Bulk Recovery Solutions Pty Ltd – Ingleburn Facility – SSD 8593

I refer to the email dated 7 June 2019 from Jessica Fountain to the Environment Protection Authority (EPA) regarding the notice of exhibition for the Ingleburn Resource Recovery Facility under SSD8593 (Proposal).

MEGAN WHELAN
Unit Head Waste Compliance
Environment Protection Authority

- NOTES
1. All trucks arriving on site must adhere to the existing BRS procedure titled "Traffic Stacking and Queuing Procedure" as updated from time to time,

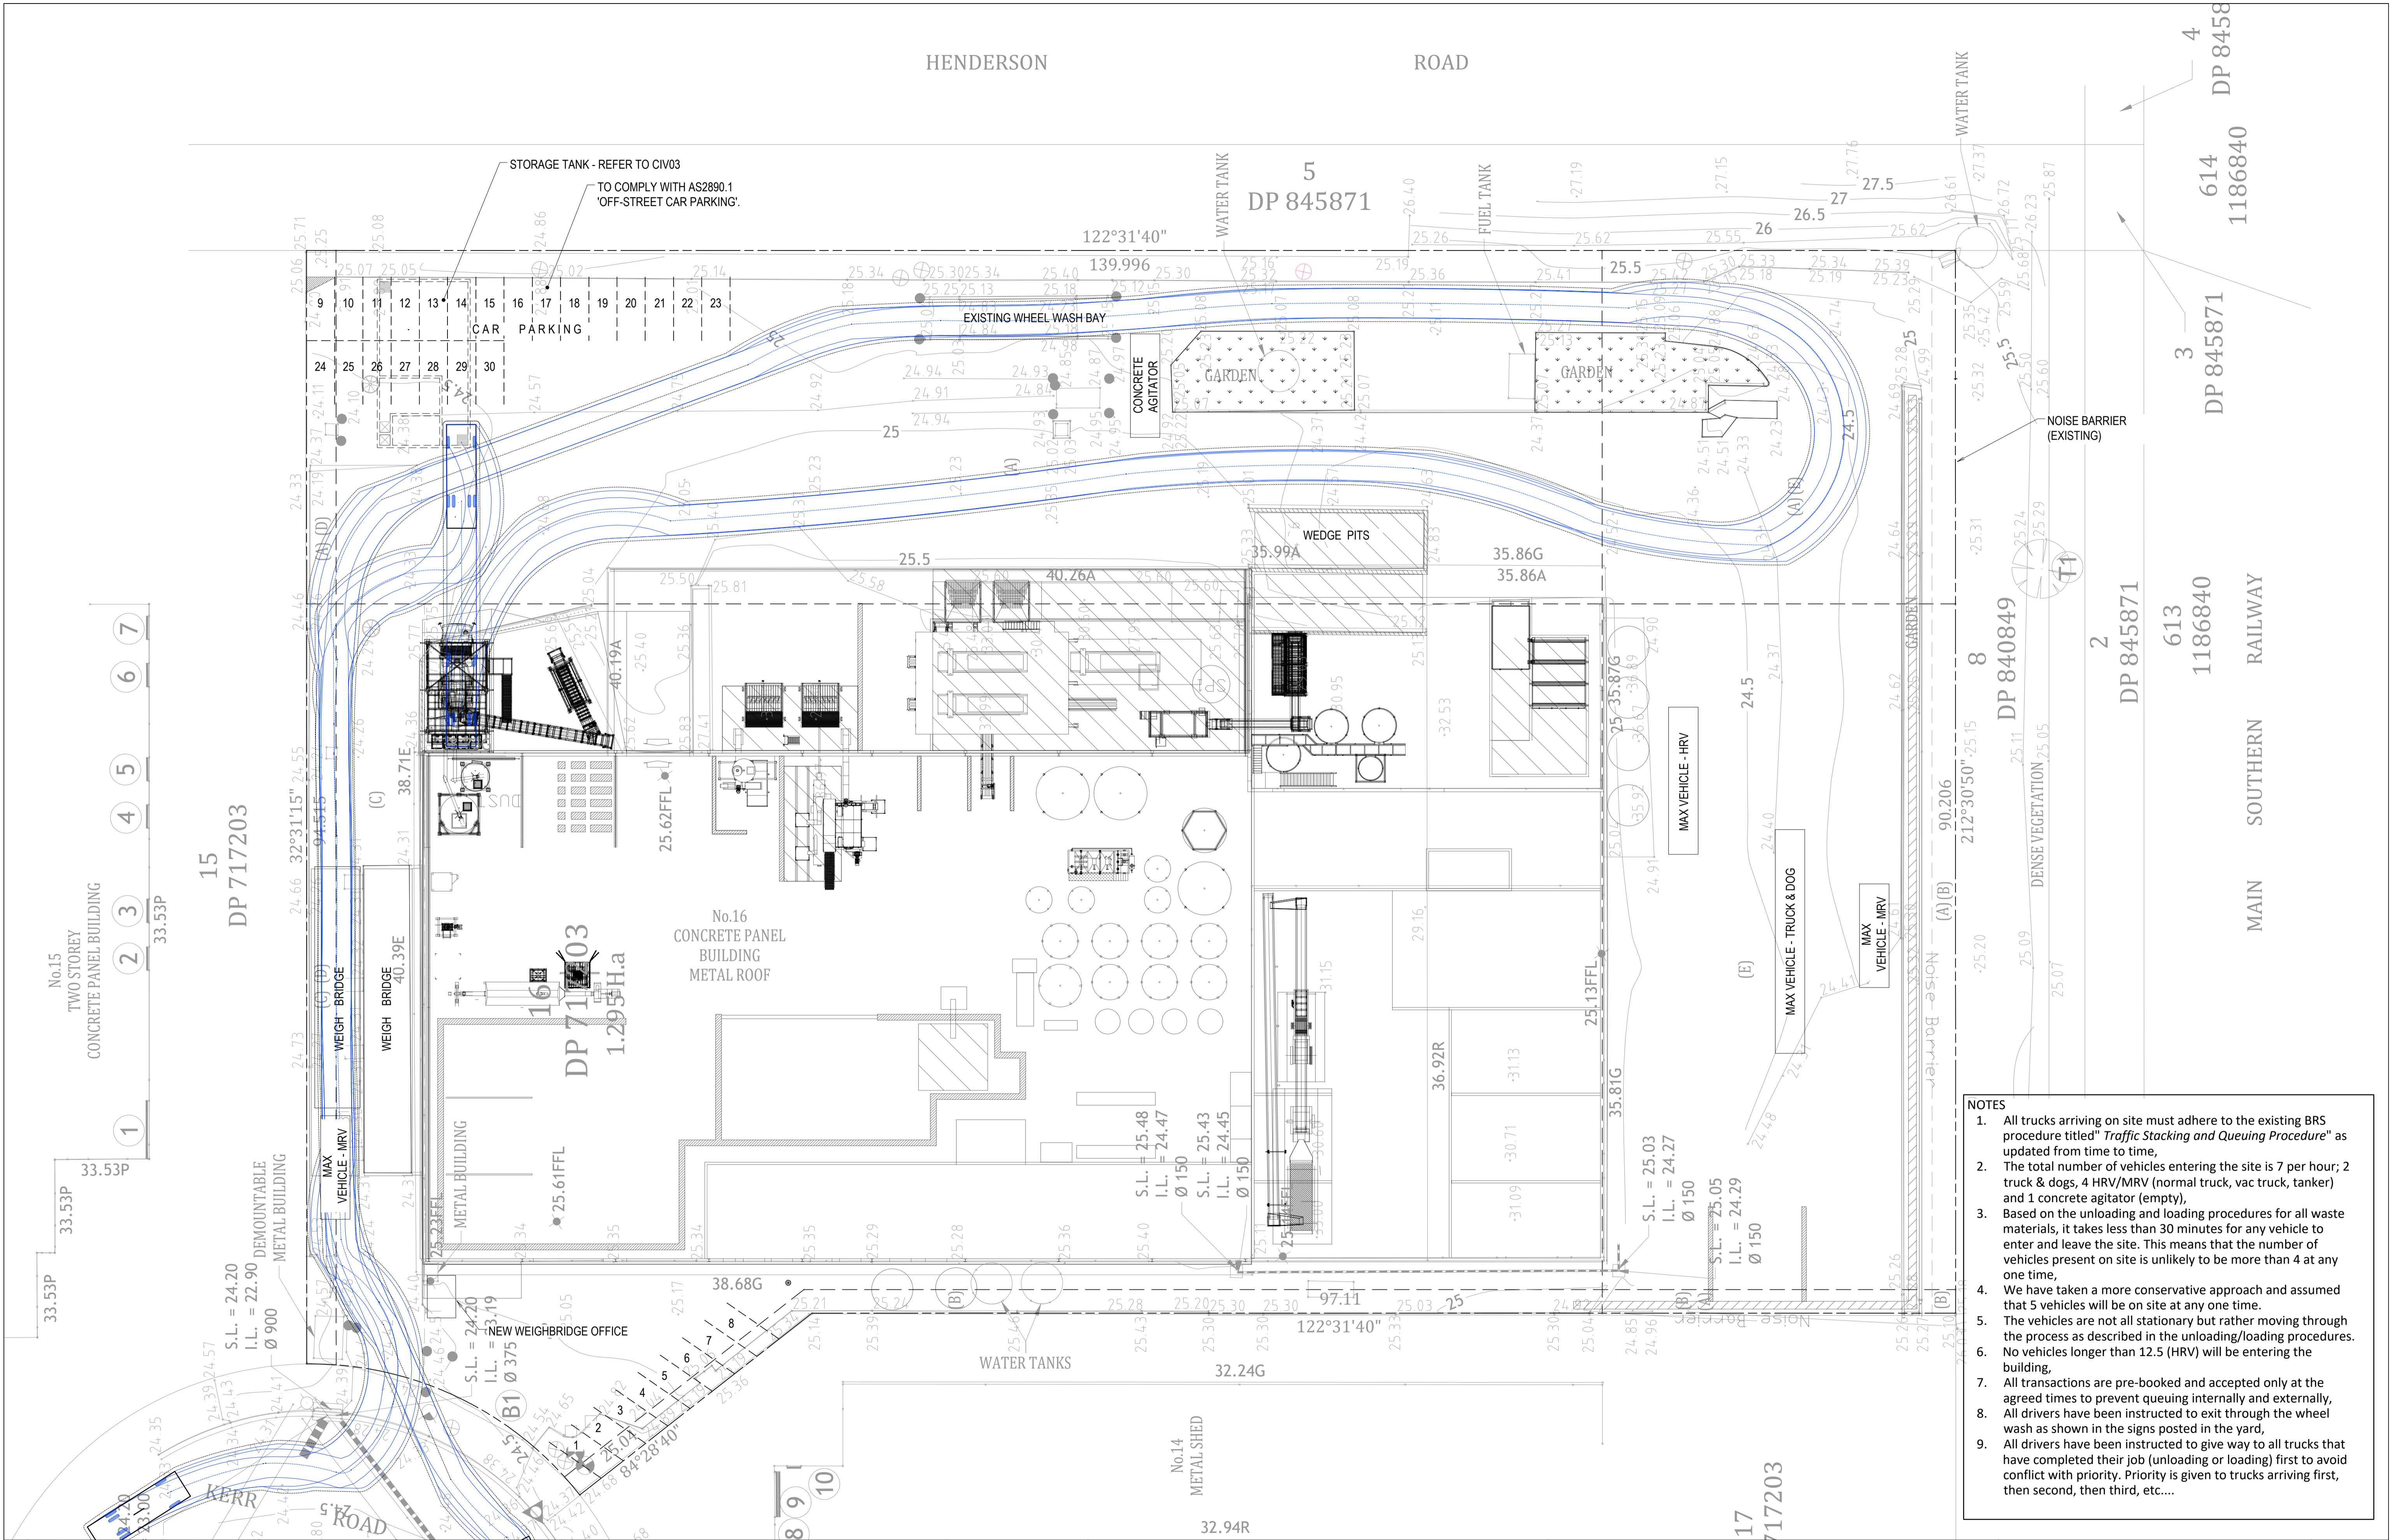
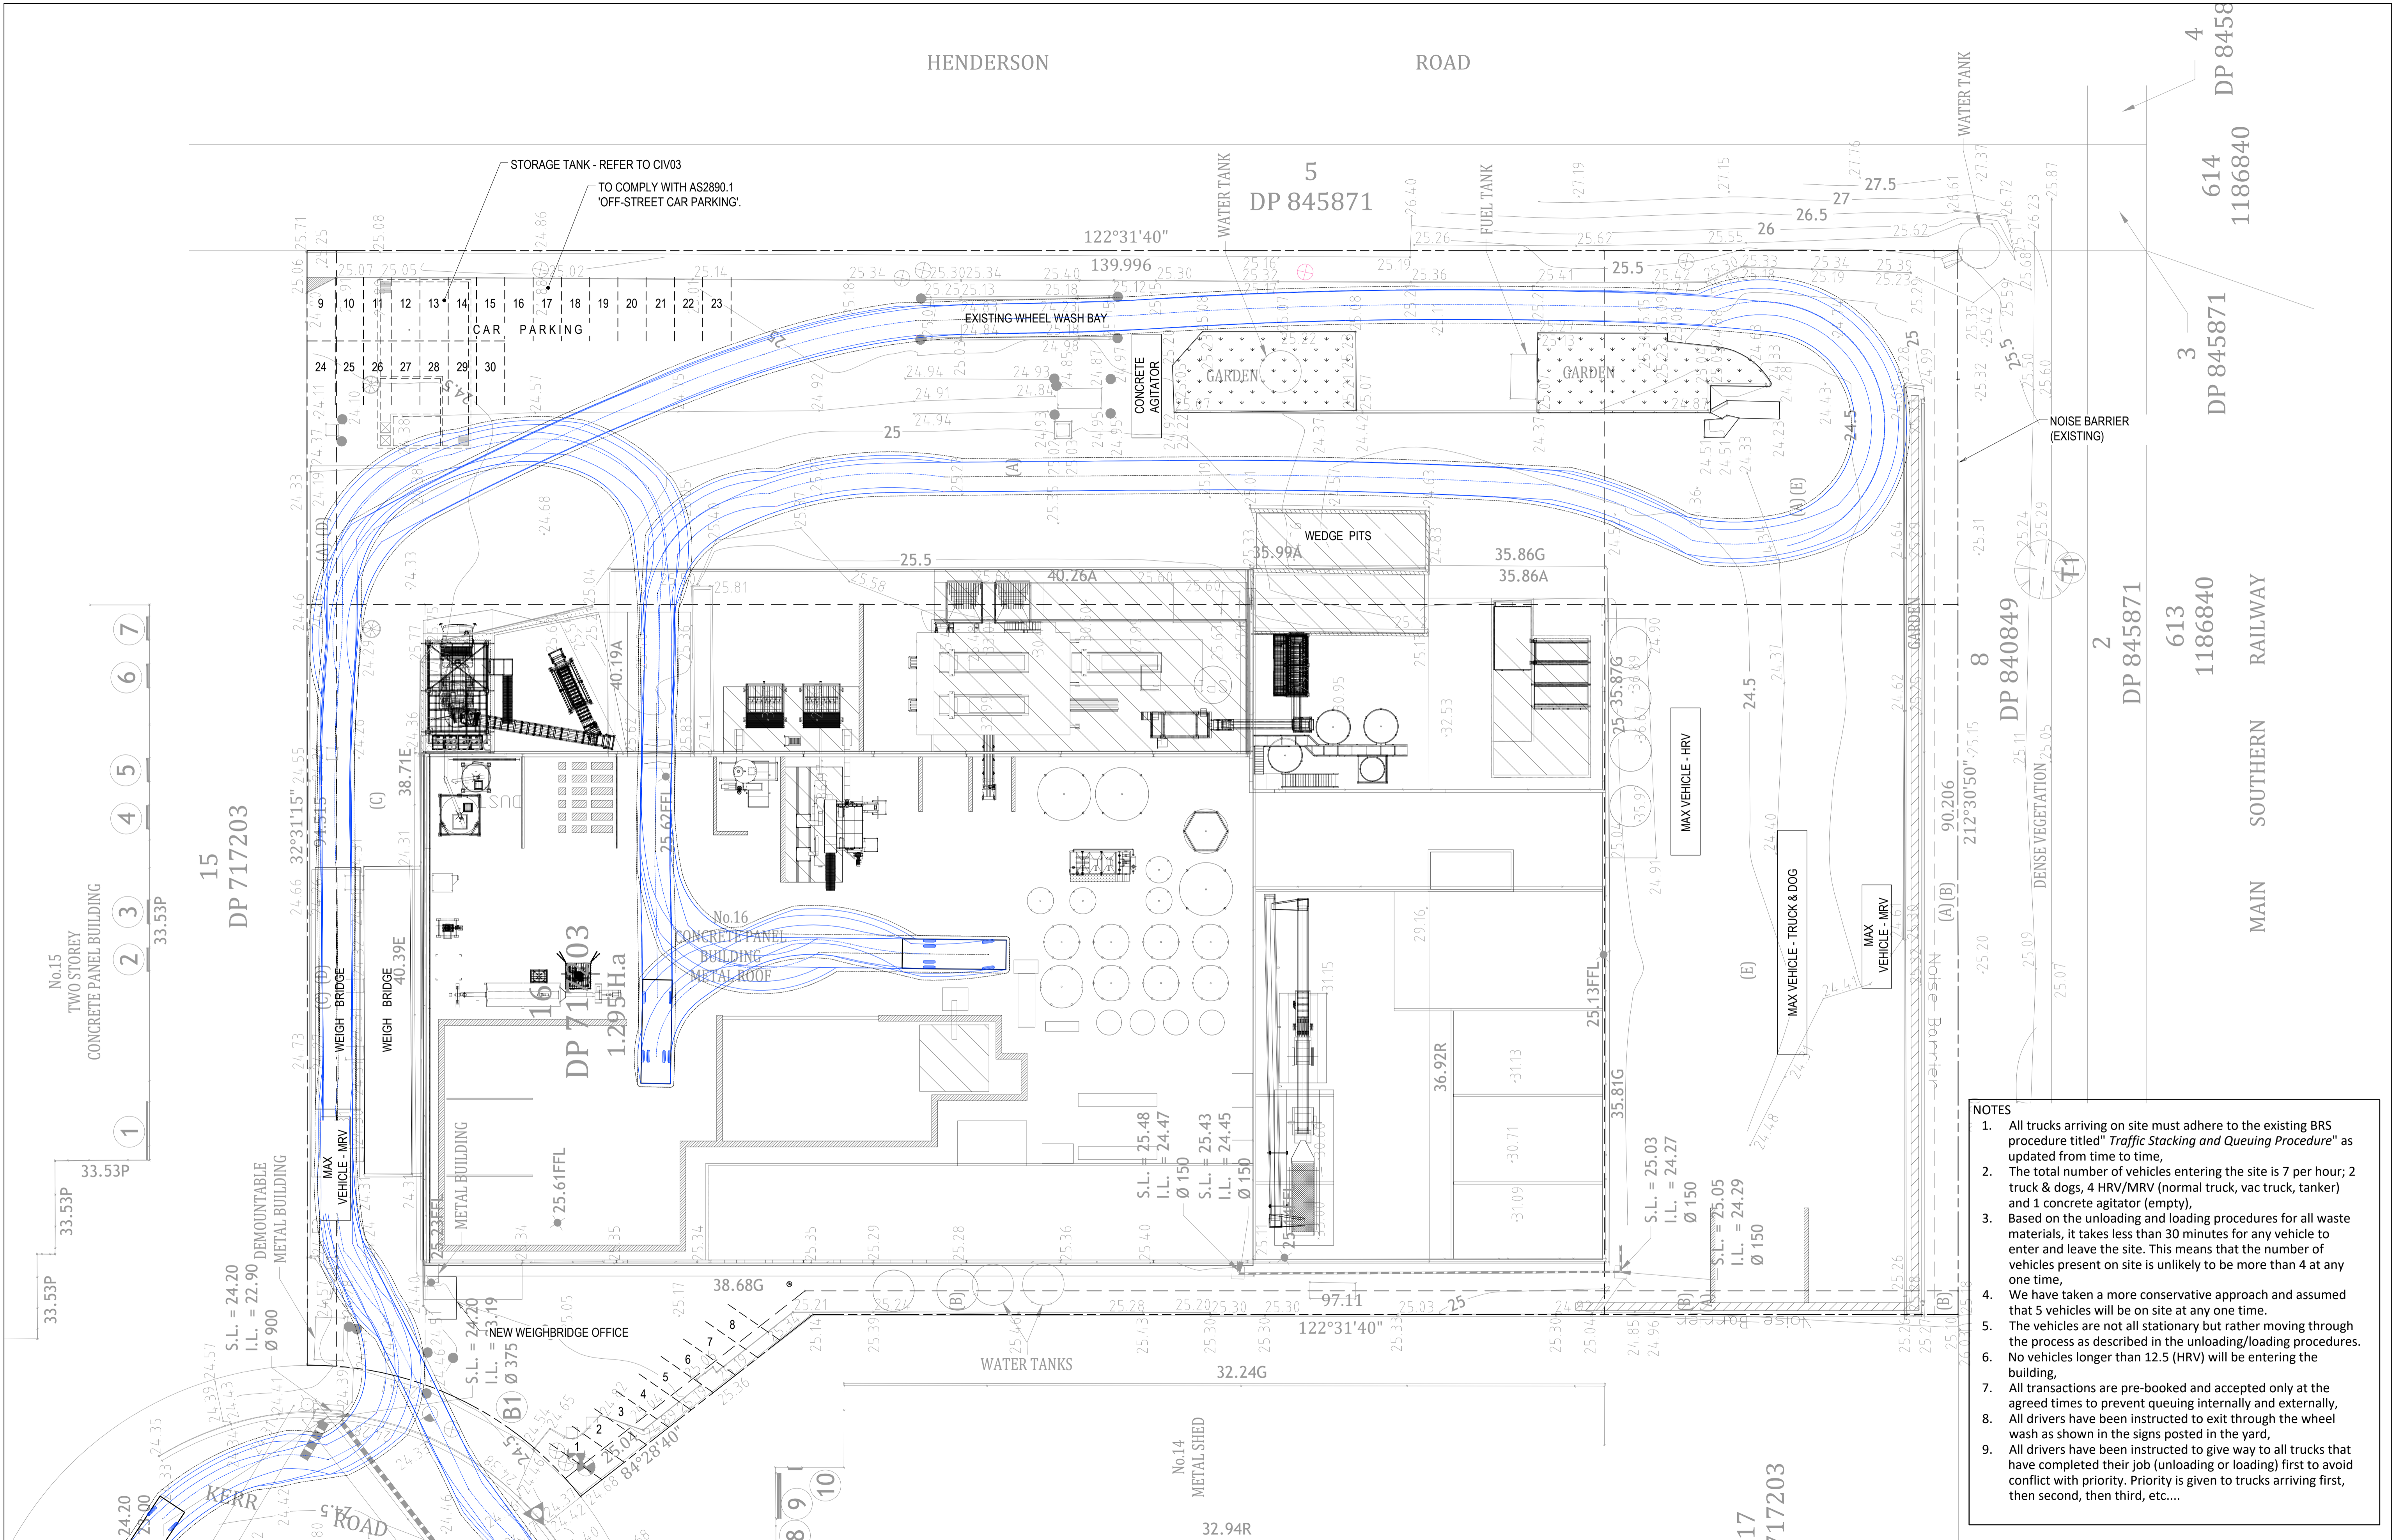
- A number of the plans submitted by the proponent detailing vehicular movement within the site show vehicle paths directly through the nominated receivals area for solid waste. We require further information detailing how the proponent will meet the EPA's minimum standards for managing construction waste in NSW, given the limited space available.
